**Hera Gold Mine Modification 3 (PA 10_0191 Mod 3)
Comment on the Response to Submissions Report**

Comment by DPI Water

DPI Water has reviewed the Response to Submissions document in support of the proposed modification to the Hera Gold Project. The following comments are provided to assist in finalising the assessment of the project.

Figure 3
APPROVED PROJECT SITE LAYOUT
AND MONITORING LOCATIONS

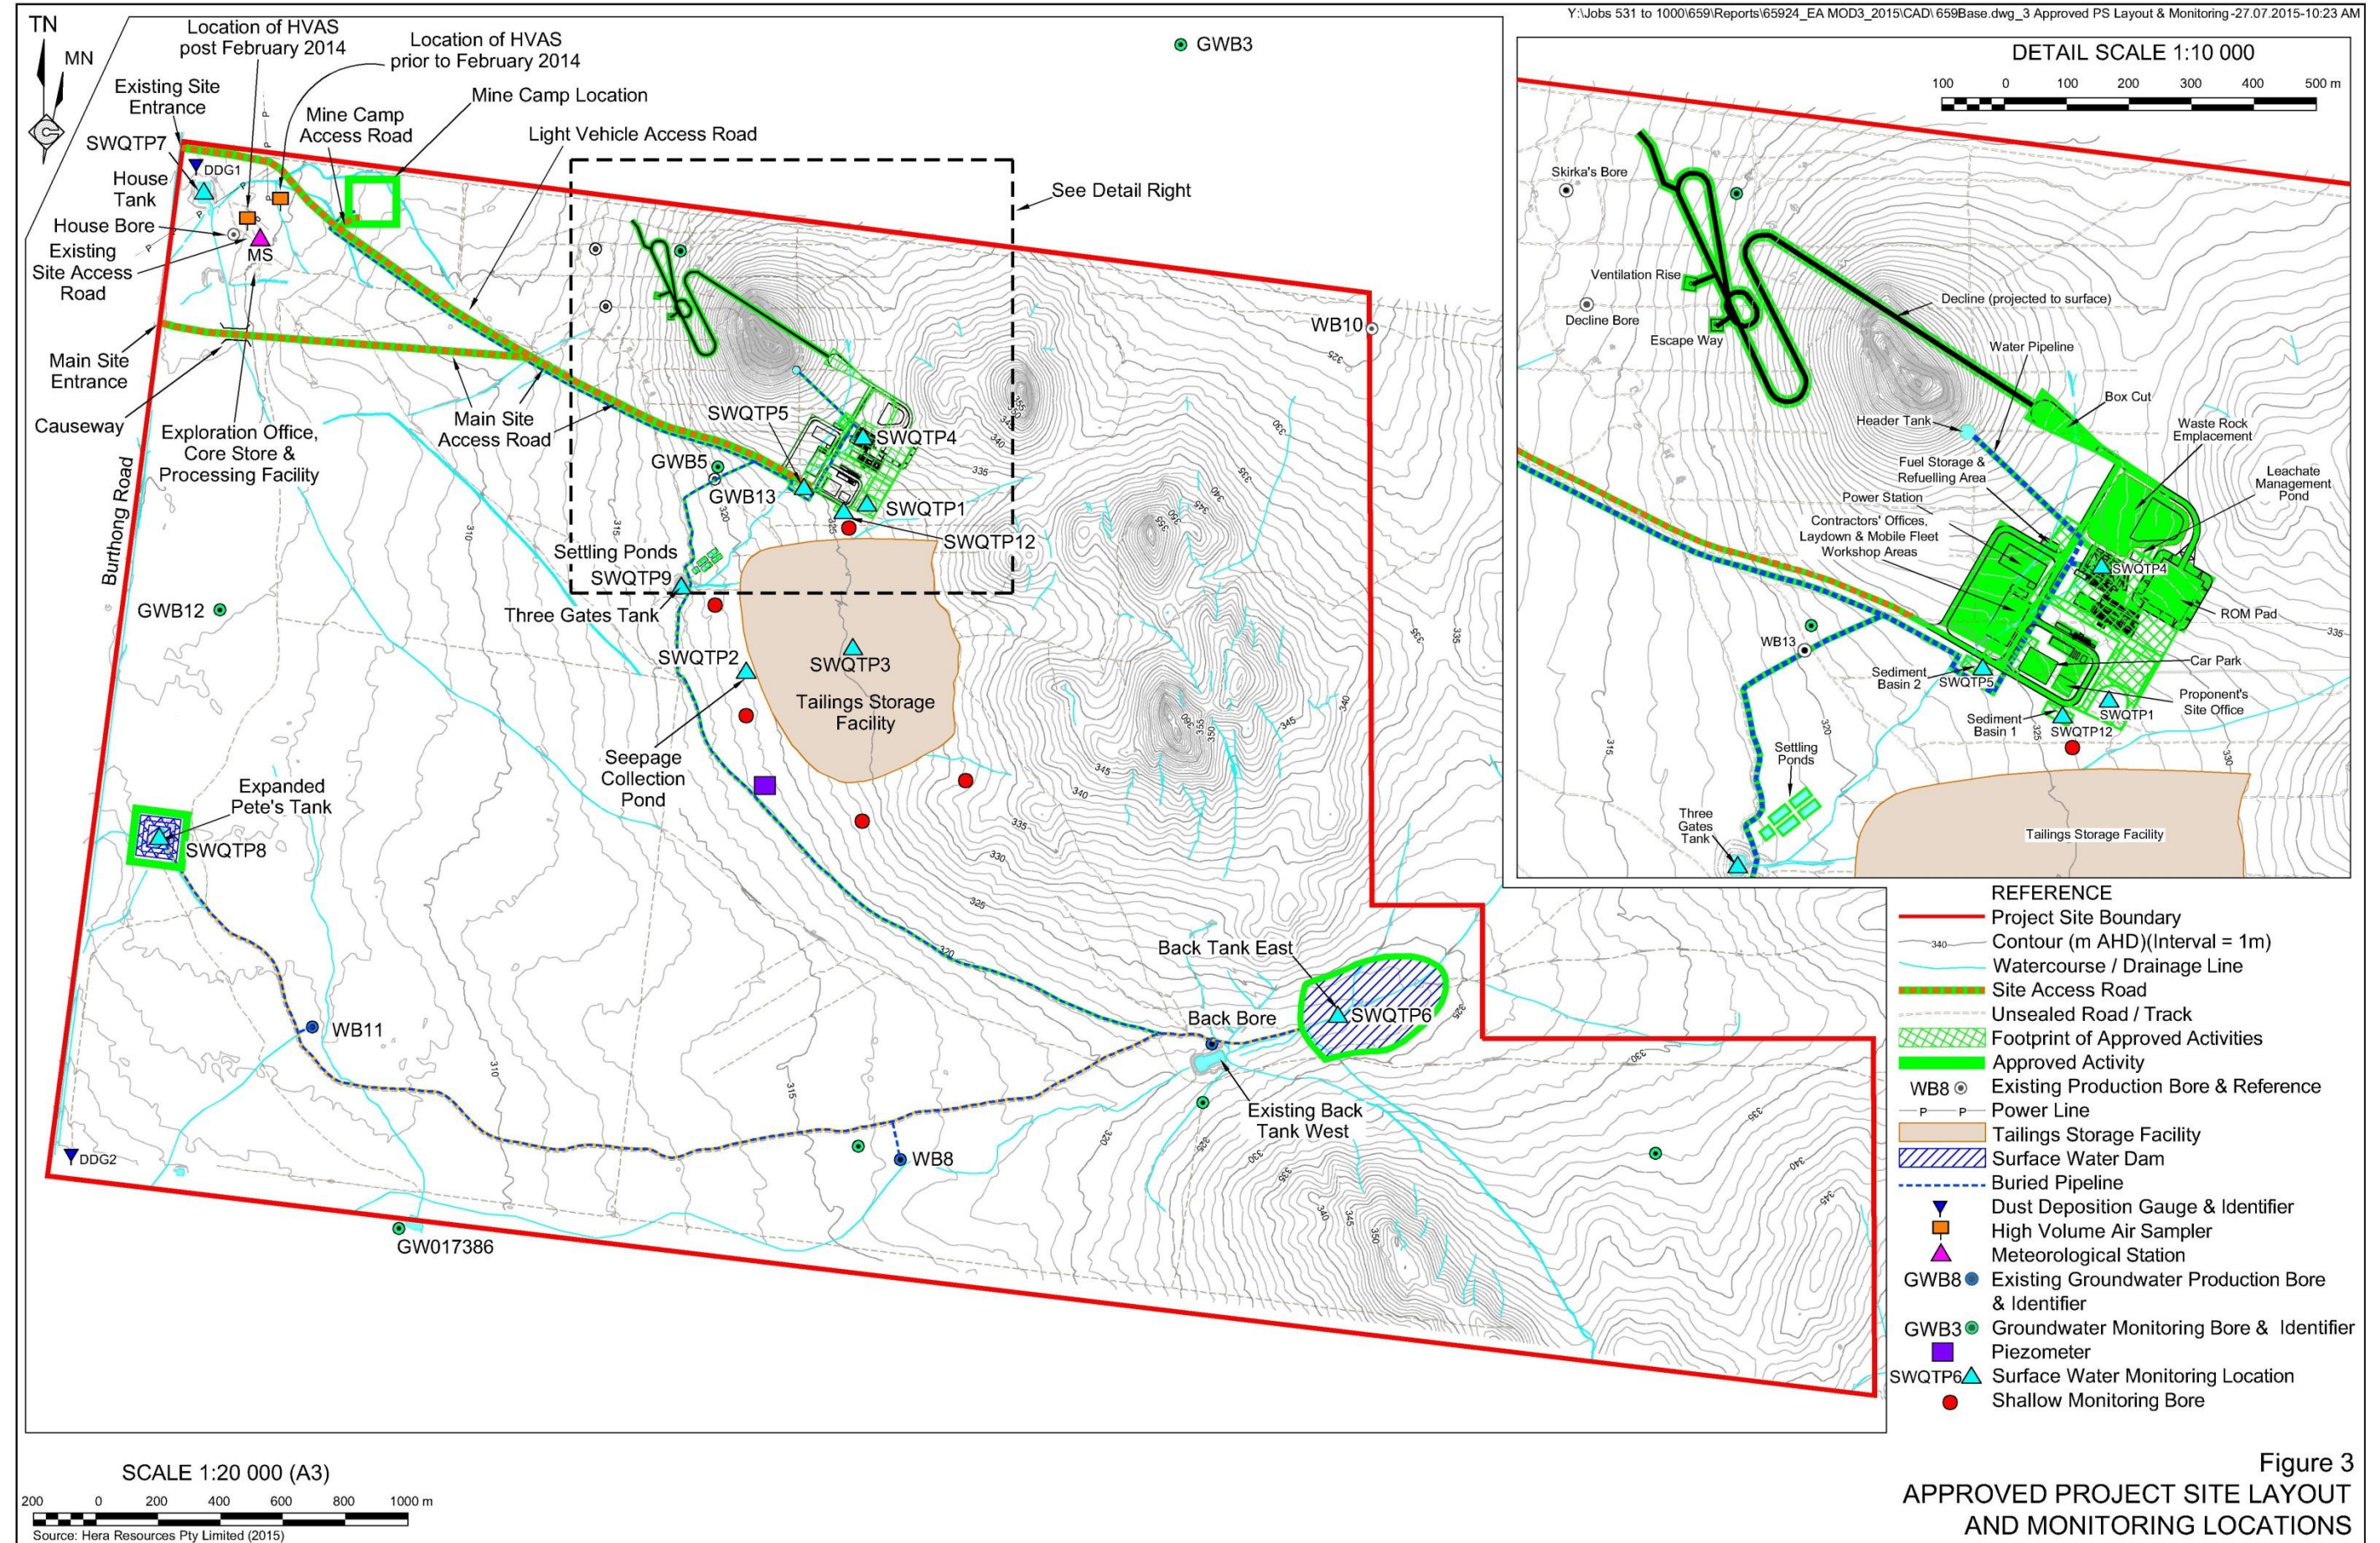
- The Water Management Plan (February 2015) states that if the trigger level of 75 mbgl is exceeded in one or more observations bores WB4, WB7, WB15, WB18 and Harland Bore, the Action and Response Plan will be implemented. The 75 mbgl trigger level originates from a trigger level placed on monitoring bores close to the production bores such as Observation Bore 2 (which has been exceeded in the past).

- A 75m trigger level for Observation Bore 2 is considered appropriate as the monitoring bore is located 180m from the closest production bore WB8. To apply the same trigger level of 75m to WB18 (which is used to manage impacts to neighbouring stock and domestic bore GW017386) at a distance of 1500m from WB8 and 700 m from WB11 is not appropriate.

- DPI Water advises the trigger levels for WB4, WB7, WB15, WB18 and Harland bore requires revision upward to consider the distance from the nearest production bore and the water levels. A trigger level of 75 mbgl at WB18 to implement the Action and Response Plan would not mitigate impacts, as based on existing water levels in WB18 a drawdown of more than 2m (AI Policy Level 2 impact criteria) to neighbouring stock and domestic bore GW017386 would have already occurred. Consideration of viable make good provisions for trigger level exceedances is also required due to the proposal of deepening bores being unlikely to increase yields.

- A condition of consent be included which requires the proponent to update the Water Management Plan in consultation with DPI Water. This is to include revision of water management infrastructure, in addition to altered monitoring and mitigating requirements.
